Our Ref: WA/88/21/DOC

Approval of details reserved by condition imposed under ref APP/C3810/V/16/3143095 (WA/22/15/OUT) relating to Condition Nos 12 - surface water drainage, 14 - maintenance & management of SuDs, 15 - foul drainage, 19 - Construction Management Plan (to incl Construction Traffic Management Plan), 20(d) - forecourt layout & drainage & intensity of all lighting, 21 noise, 25 - Travel Plan and 26 - Non-Motorised Users Audit.

Global Technologies Racing Ltd Arundel Road Fontwell BN18 0SB

Arun District Council have decided to **REFUSE details reserved by condition for the following reasons:**

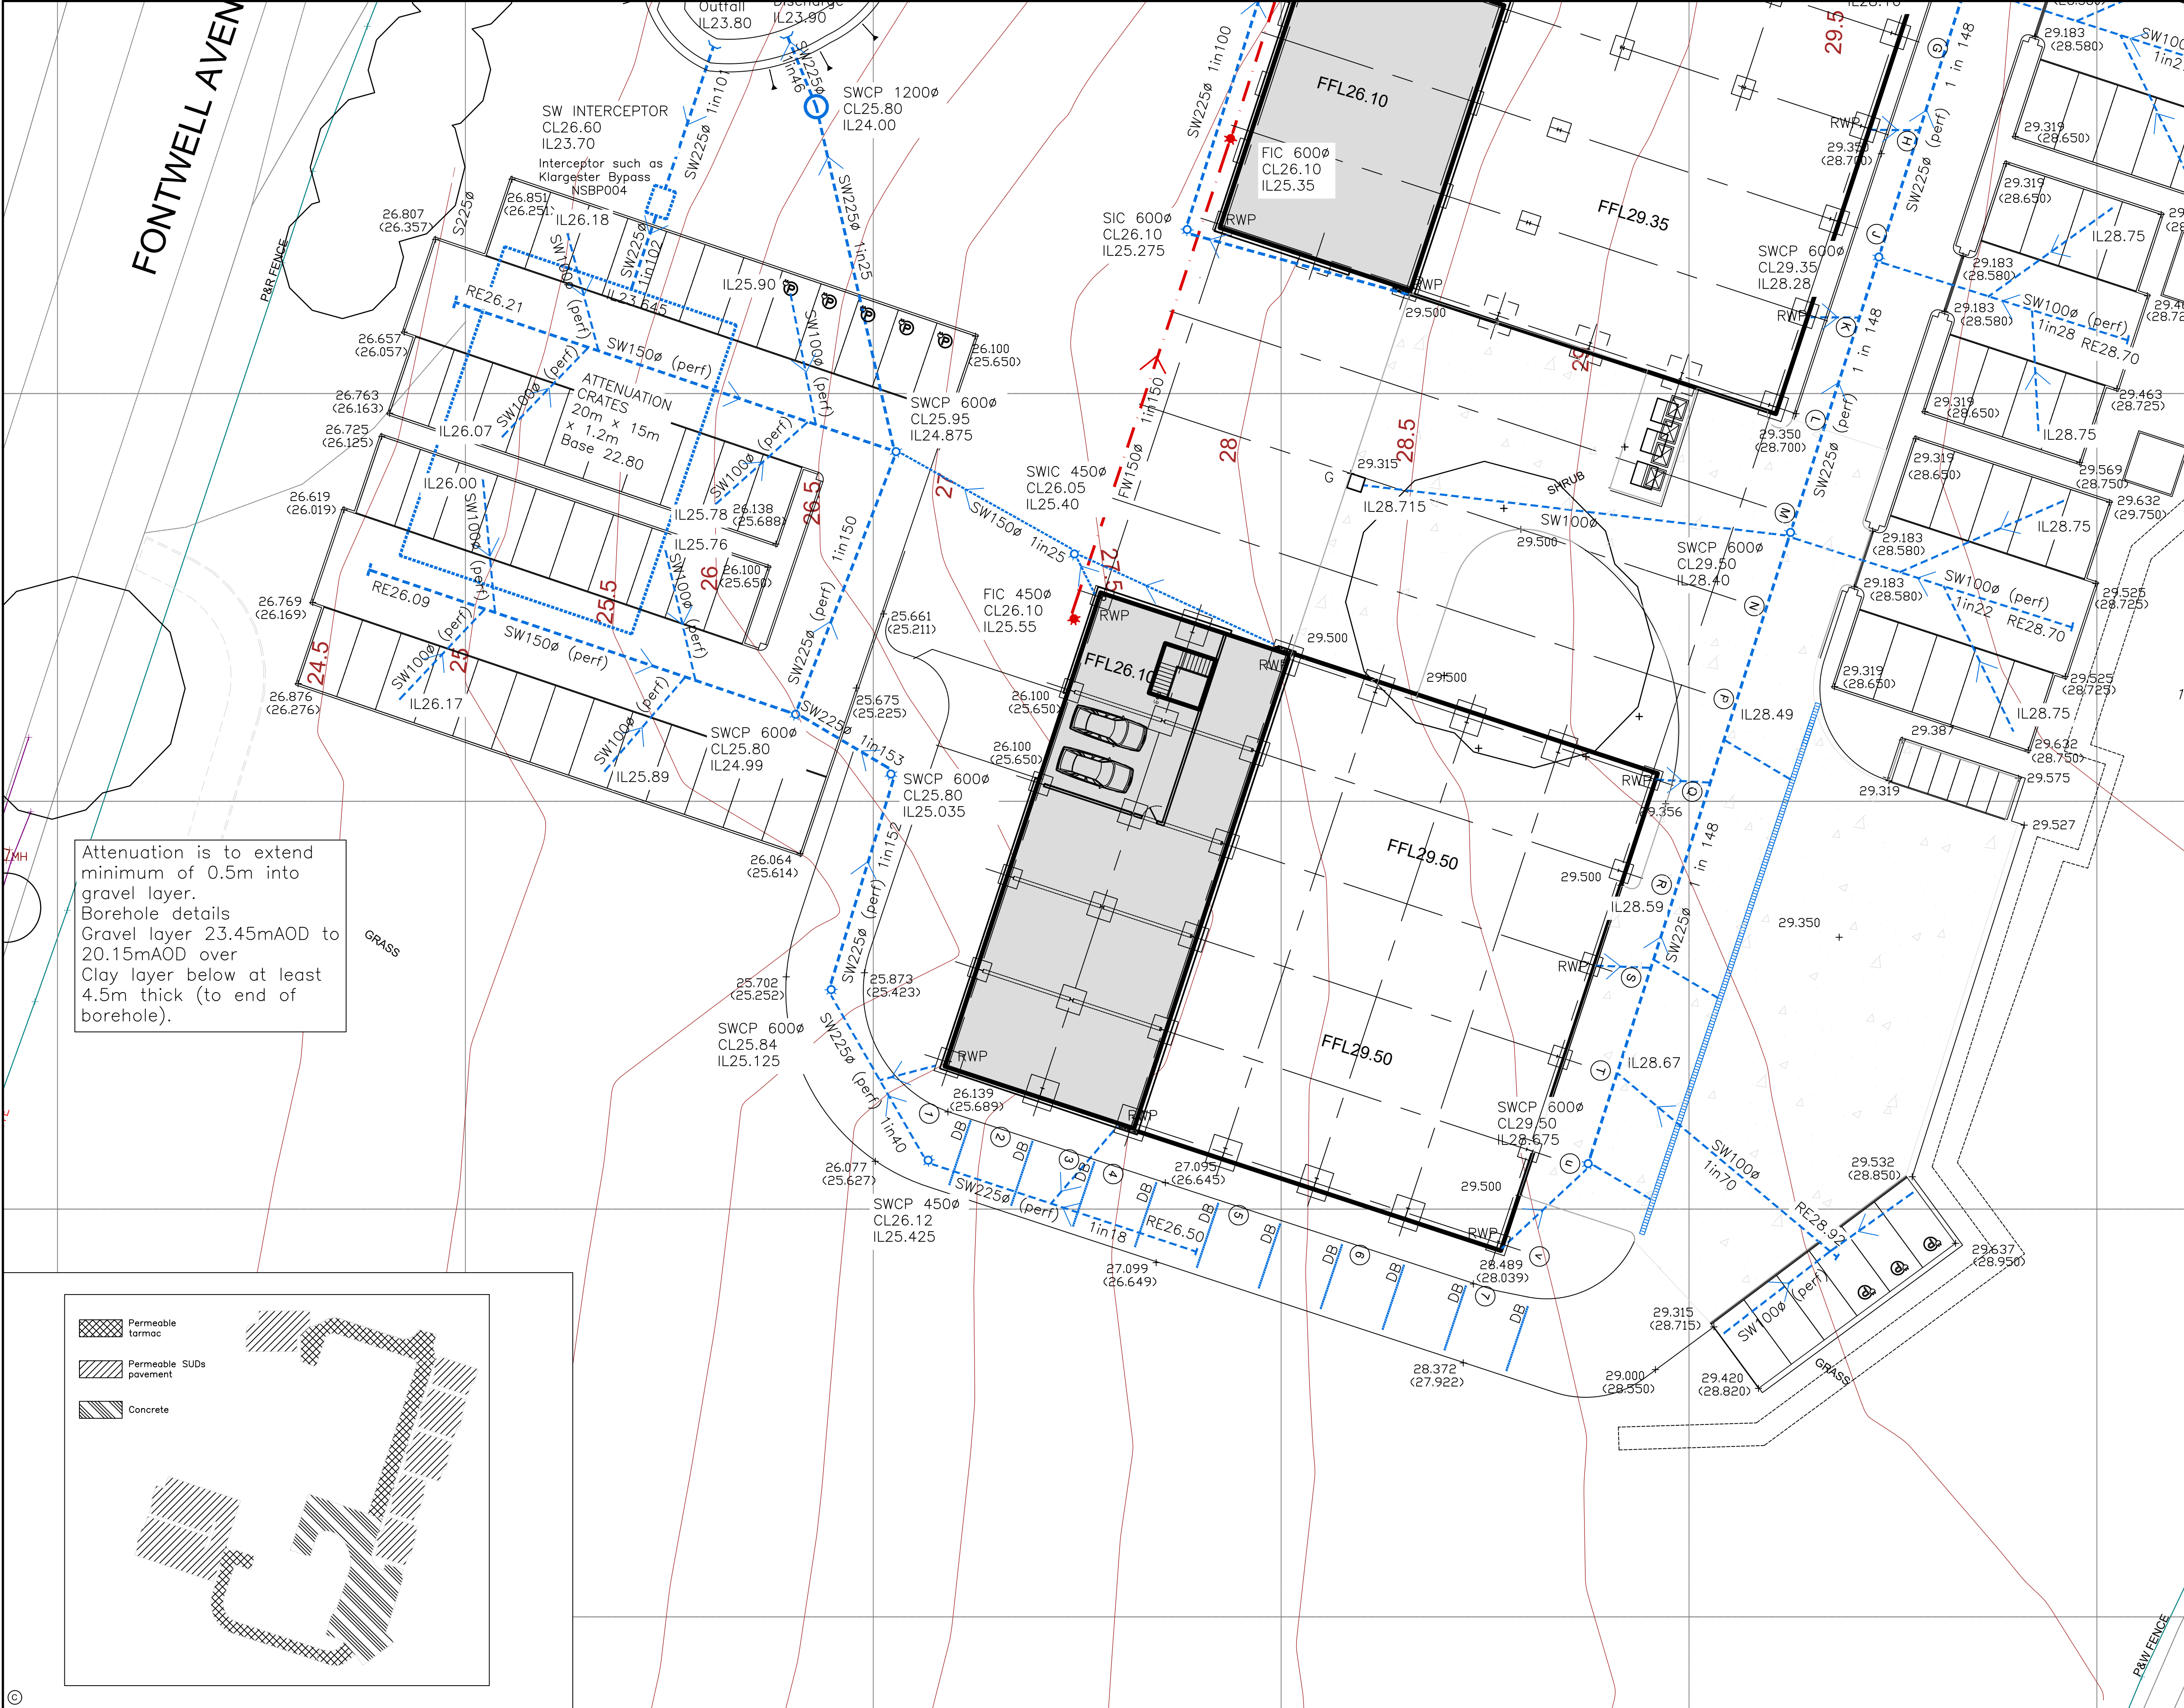
1. Permeable paving extents are not very clearly shown, a small insert layout is provided on one layout only. Permeable paving extents should be clearly shown on all layouts.

2. Catchpits still have not been provided upstream of connections into permeable paving sub-base. Stating that there will be filter socks is insufficient. We acknowledge that the filter socks will prevent silt ingress into the sub-base, however over time the permeability of the filter material will decrease as silt builds up on it, with no easy means of maintenance.

Attenuation Pavement and Perforated Pipe Detail

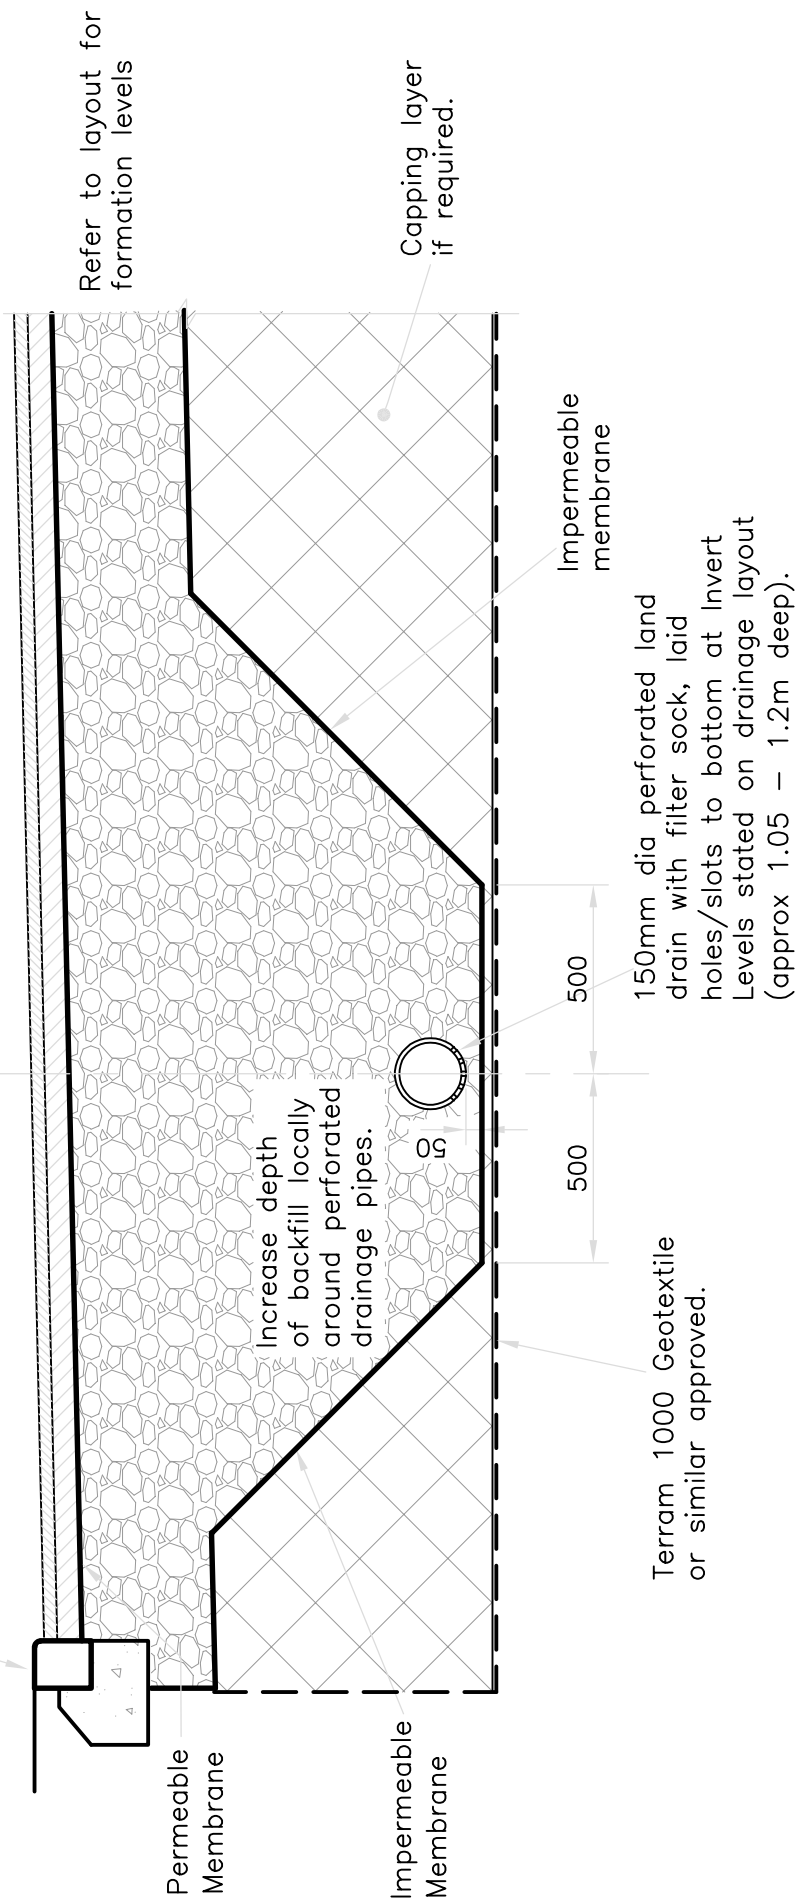
3. It is not possible to review if appropriate cap volume depths have been applied to calculations without a more detailed construction detail drawing of the permeable paving.

5. Permeable paving construction detail drawing should fully detail the entire construction.

Typical Flow Control Details

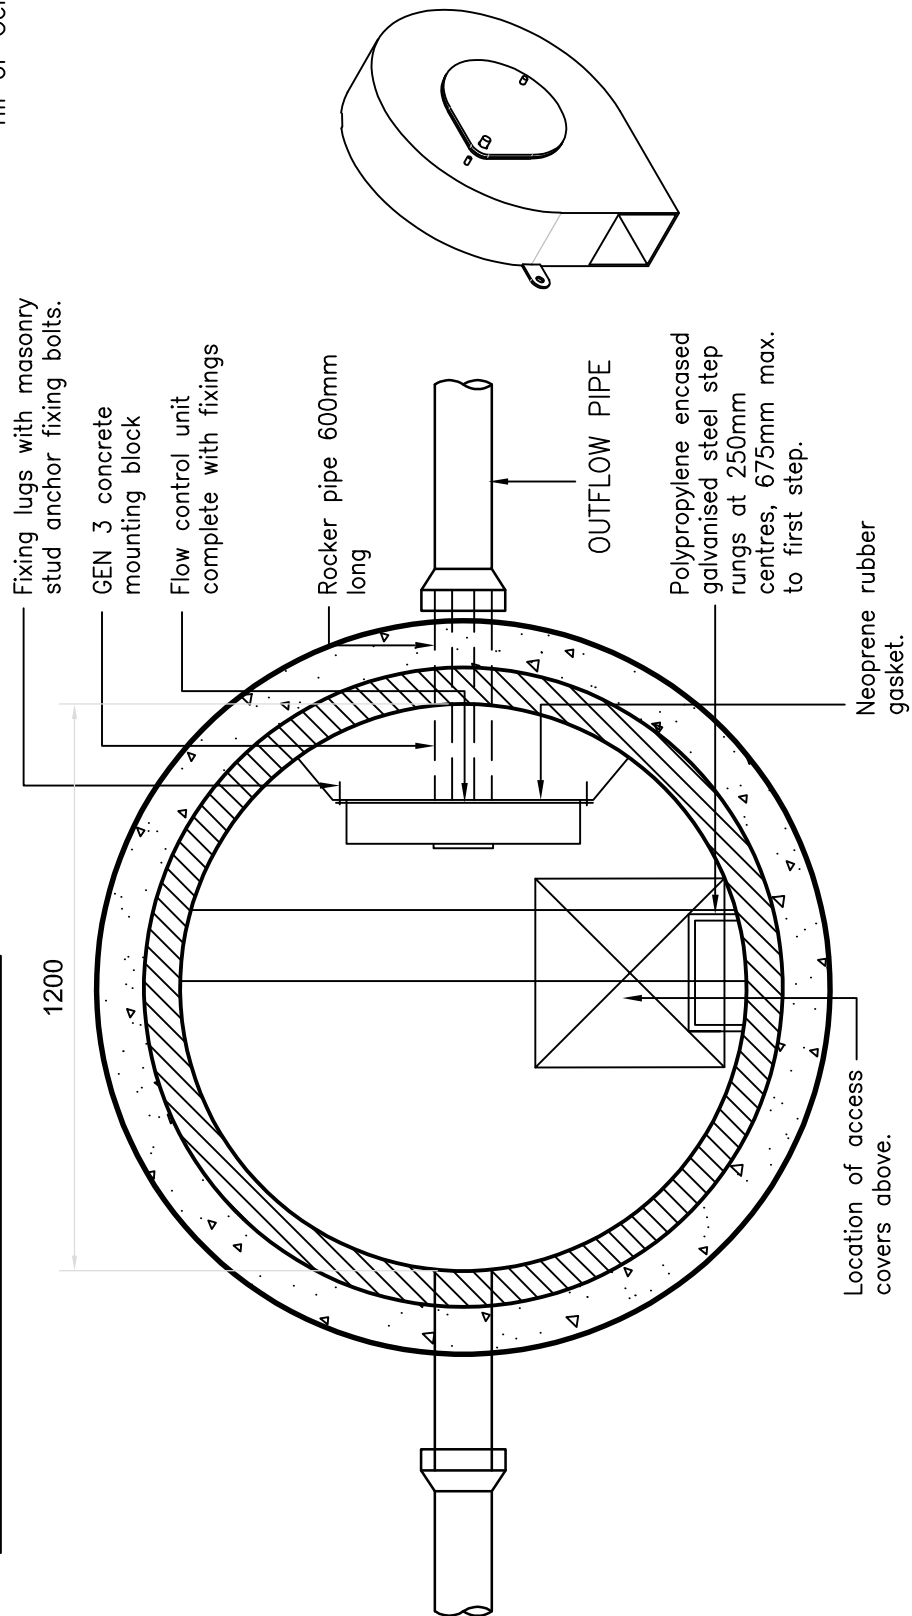
4. Construction detail drawings should be site specific. So there should not be a hydrobrake included on details. Construction details of the infiltration basin should be provided including the headwalls into this.
